Date 24 February 2017

Dr Michael Barry  
BMT WBM Pty Ltd  
PO Box 203  
Spring Hill QLD 4004

**Review of Explanatory Note – West Culburra Concept Plan and associated documents**

TYPICAL 7m ROAD IN 23m ROAD RESERVE CROSS SECTION
FOR ROAD 08 WITH WATER QUALITY CONTROL
SCALE 1:50

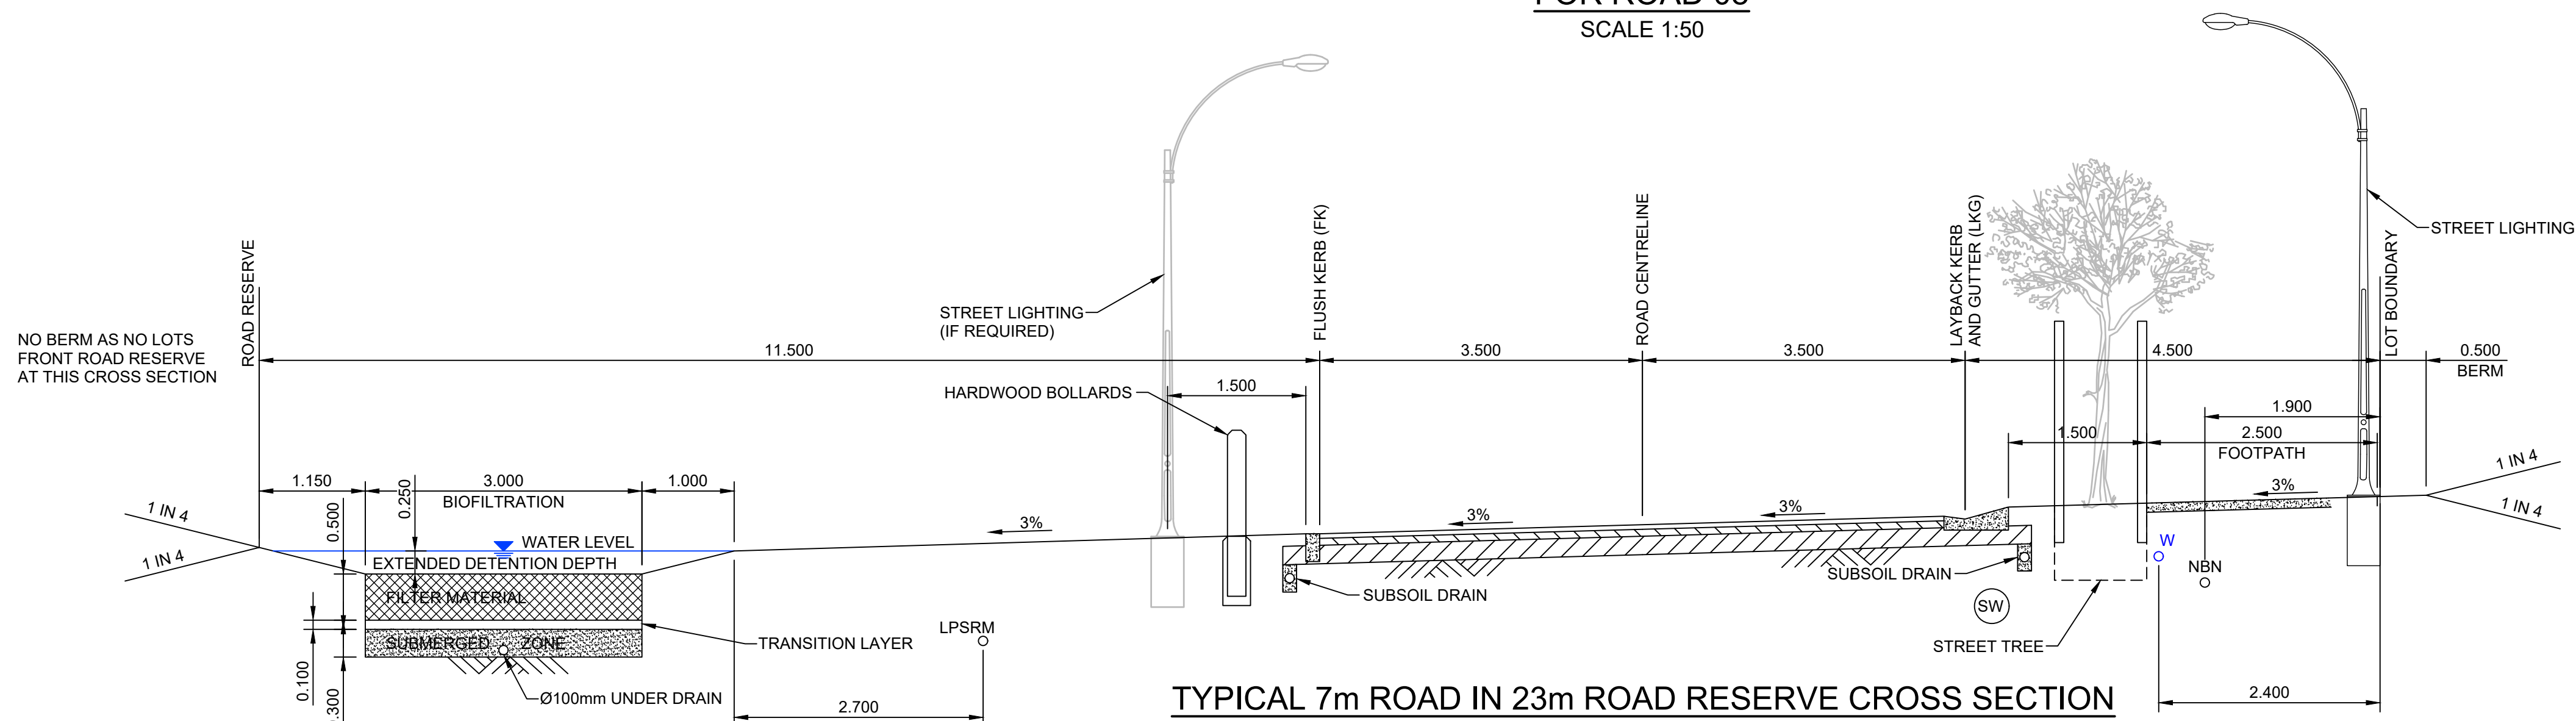
- The proponent suggests that the design of their "within road" bioretention swale can wait until the detailed design stage, however this is a key component of their strategy, so without this design we are unable to assess whether the proposed system would function properly and deliver the level of pollutant reduction required. This reduces our confidence that the strategy would deliver the required outcomes for the development.
